CITY OF ALBUQUERQUE

**RE: Arroyo Vista Median Swale
Grading and Drainage Plans
Engineer's Stamp Date: 06/6/19
Hydrology File: J08D005, CPN 651182**

Subject: Arroyo Vista Median Swale

ARROYO VISTA MEDIAN SWALE
(INTERIM CONDITION WITH
ONLY NORTH SIDE OF
ROADWAY BUILT)

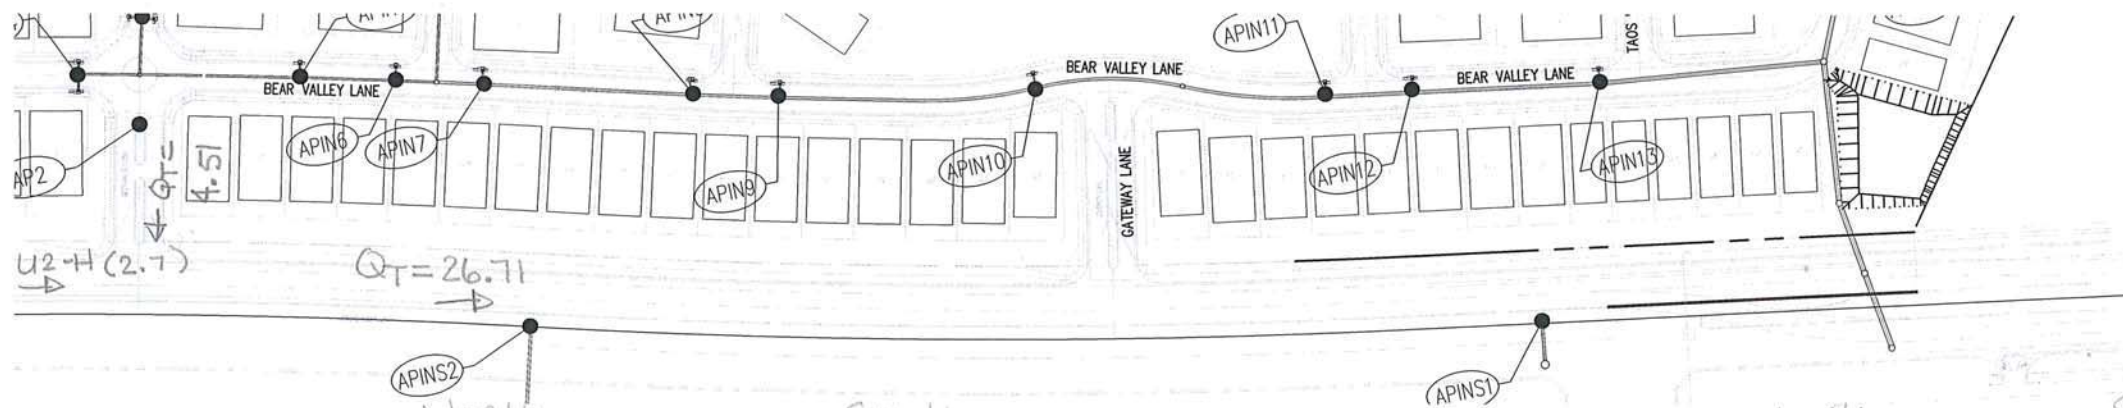
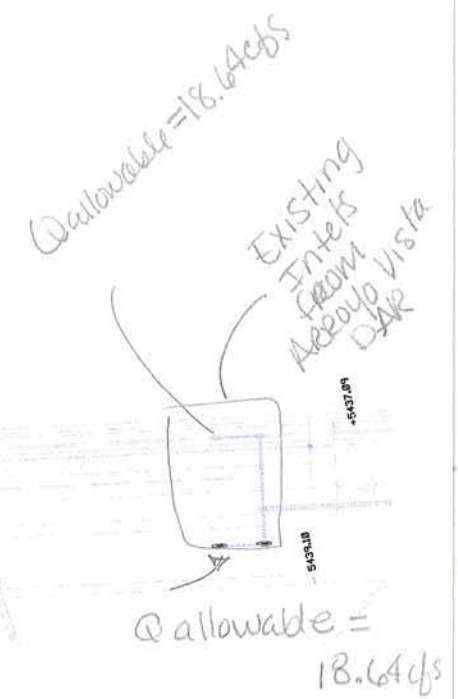
1. Per the DPM Figure 6.9.9, the capacity of a double inlet at 0.7' of depth at 0.2% slope is 10 cfs. The submittal states there is 29 cfs. The inlet appears to be undersized. The city does not count the 'throat' for its inlet capacity as is it there in case the grate plugs, which happened during the storm event referenced above.

2. From a site visit it appears that 2/3 or so of Basin OS-2 drains to Basin U2-H before entering Arroyo Vista Blvd ROW. Grades were altered during wall construction, so existing grades cannot be used. In addition, the land was driven/worked on. Please update the basin calcs to 2/3 of 1.36 acres= 0.9 acres and use 100% Type C land treatment. In addition, Basin OS-2 should be broken up into two basins as there are two outfall locations. This would also allow for an "Arrow" showing the outfall location through Basin U2-H.

3. Update the calculations for the inlet at the east end of the swale with the revised flow rate.

4. For Basin OS-1, move/point the flow arrow so that it is clear that this basin drains to the arroyo located south of the Arroyo Vista Blvd ROW.

The information you provide is for an inlet that is on-grade. We are in sump condition. The inlet is sized adequately in sump. We prepared a side weir calculation that indicated 16' of width of curb needed to be removed to pass the flow into the location of the sump inlet. I have attached the submittal and approval to this letter.

After a site visit, I disagree that 2/3 of Basin OS-2 gets to Arroyo Vista. I stand by my revised calculation that 14% of OS-2 drains to Arroyo Vista with the remaining portion draining over the walls and into the subdivision. However, the 2/3 portion was calculated along with the 14% and are listed below. I have added the 2/3 of Basin OS-2 of 2.6cfs to the inlet location downstream and the inlet can still accommodate this additional 2.6cfs. See enclosed revised exhibits enclosed.

See response above and exhibits enclosed.

Flow arrow was previous shown just to light. it has been updated to remove previous arrow and darken new arrow
